From: Cleaver, Elizabeth [REDACTED]
Sent: 18 February 2022 23:04
To: Planning.Responses <Planning.Responses@arun.gov.uk>; Simon Davis <Simon.Davis@arun.gov.uk>
Cc: Planning SE [REDACTED] Spatial Planning [REDACTED]
Subject: National Highways response: Y/3/22/OUT, Land West of Bilsham Road, Yapton

National Highways Planning Response (NHPR 21-09)
Formal Recommendation to an Application for Planning Permission

Council's Reference: Y/3/22/OUT

Location: Land West of Bilsham Road, Yapton

Appendix C – A27 Mitigation Scheme

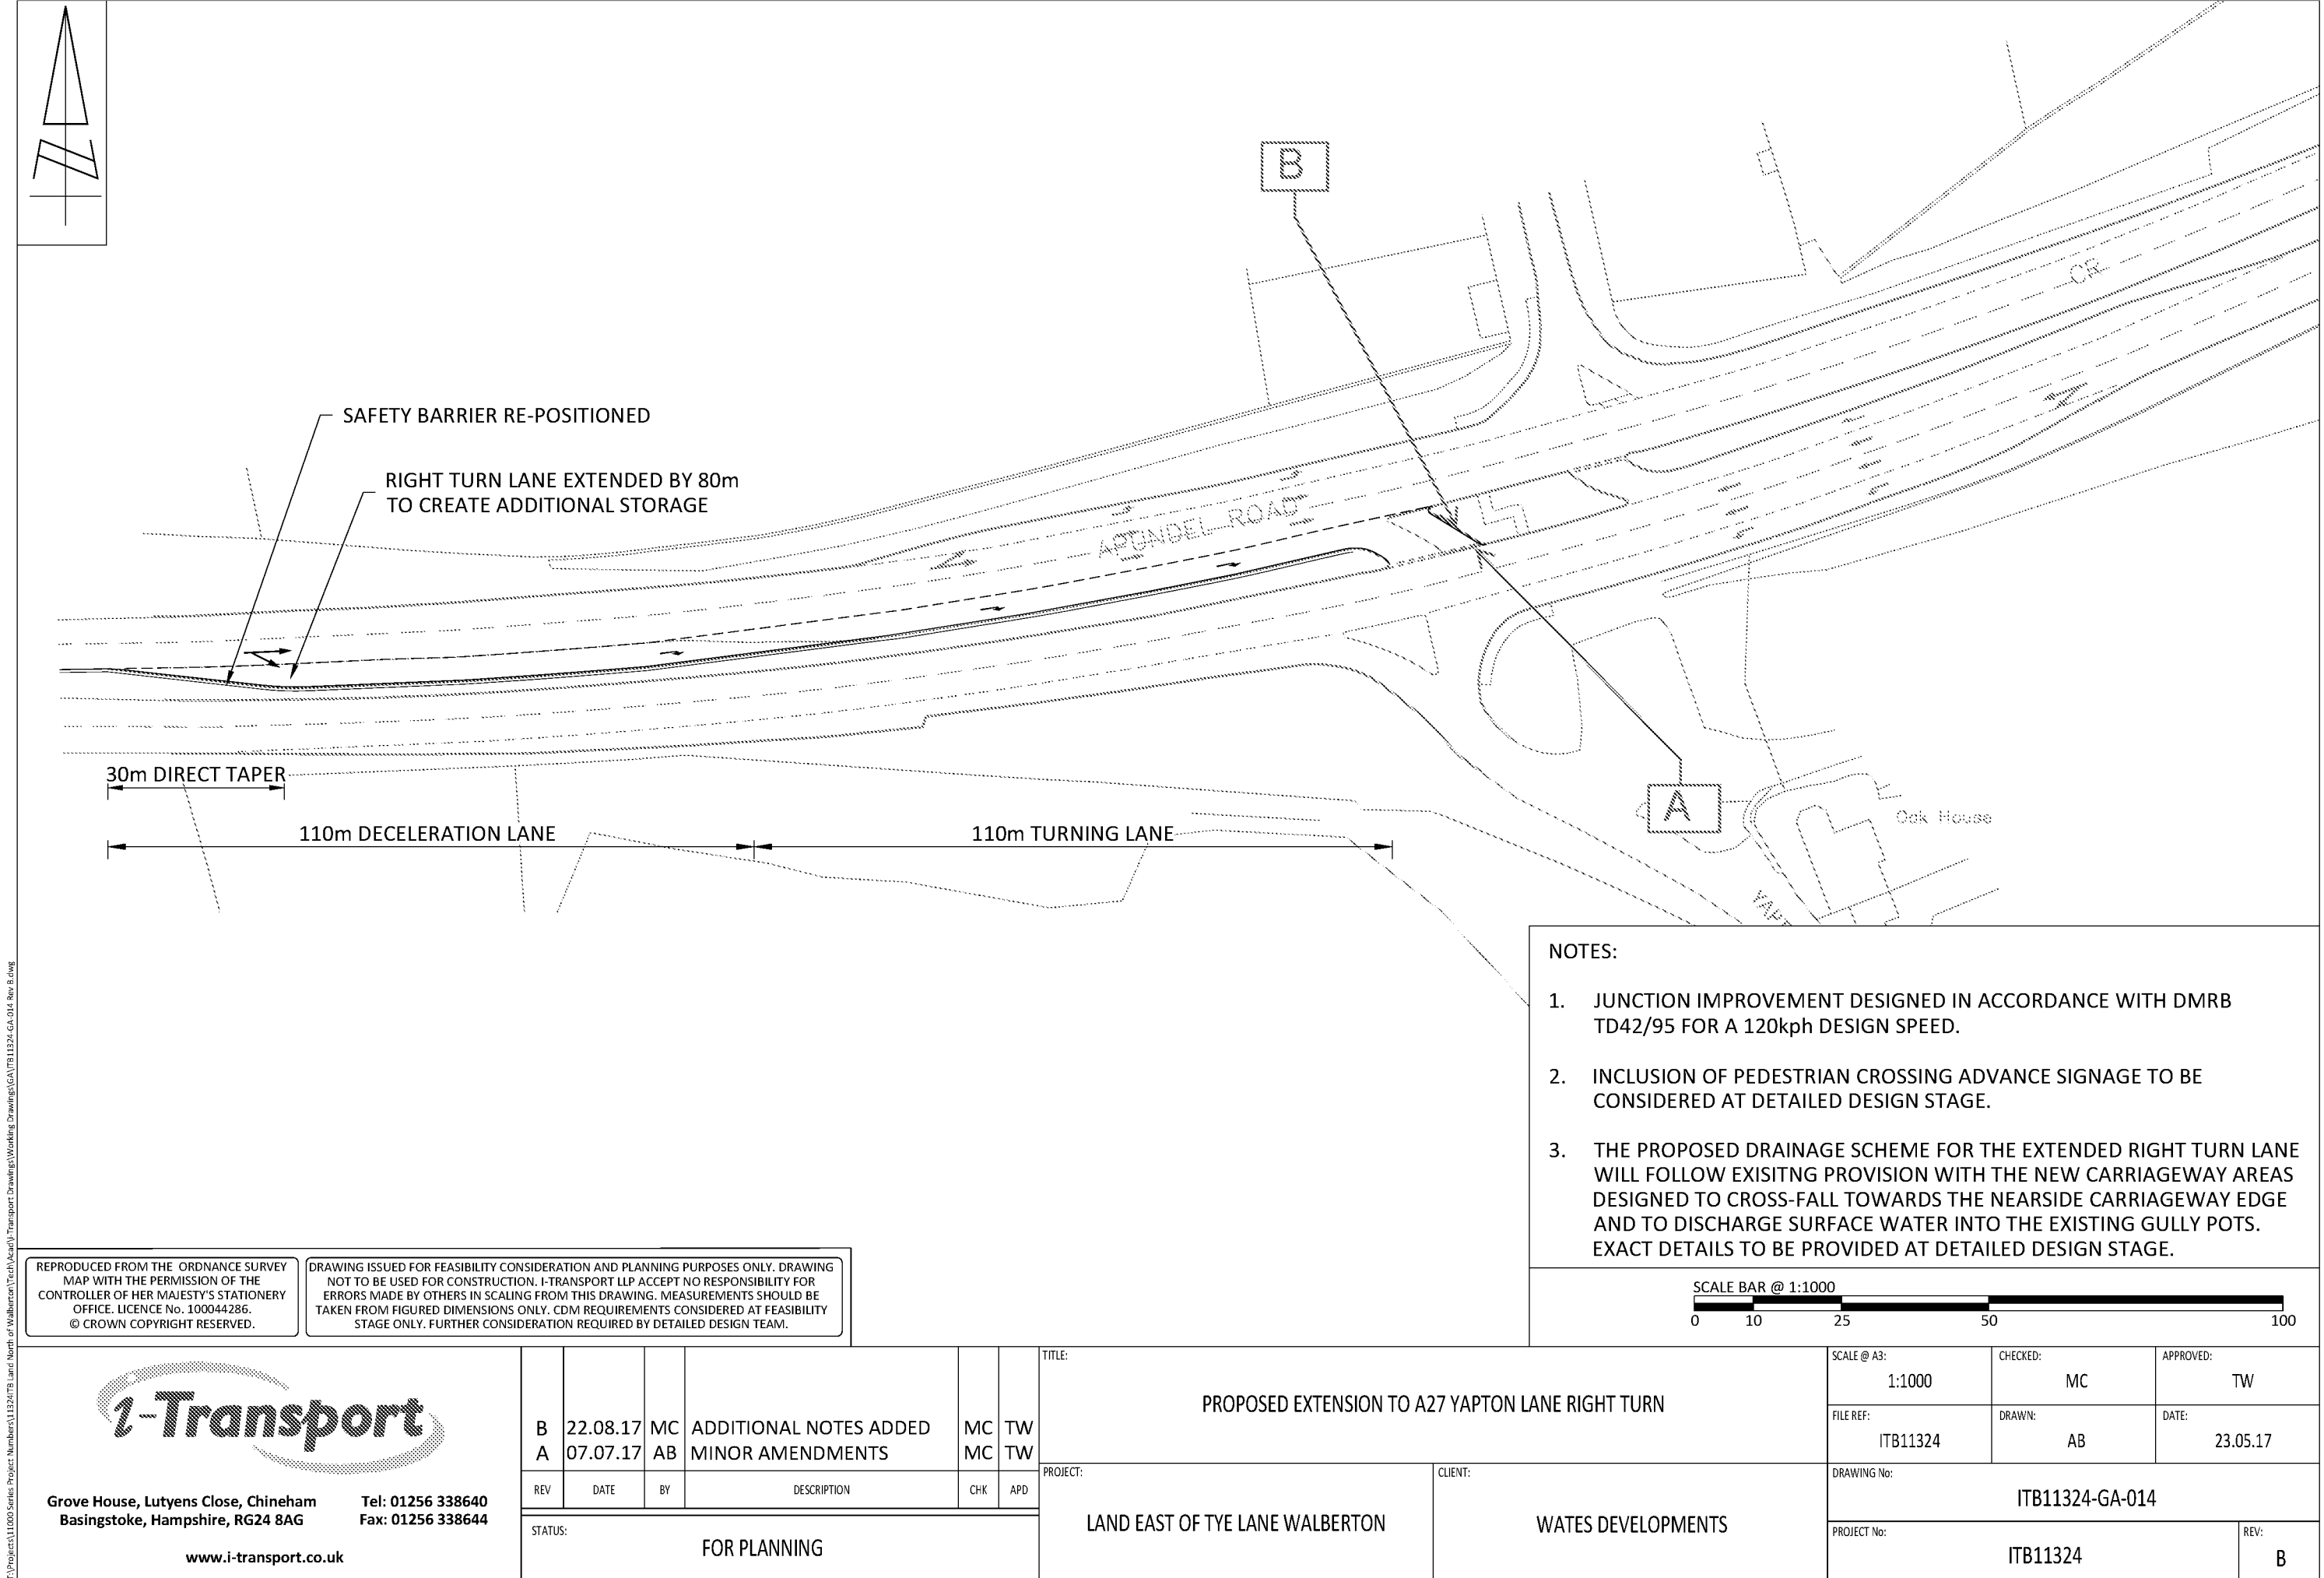
There is an agreed mitigation scheme for the A27/Yapton Lane junction, as shown on drawing number ITB11324-GA-014 Revision C. The results of the detailed junction modelling will inform our decision on whether any further mitigation is required.
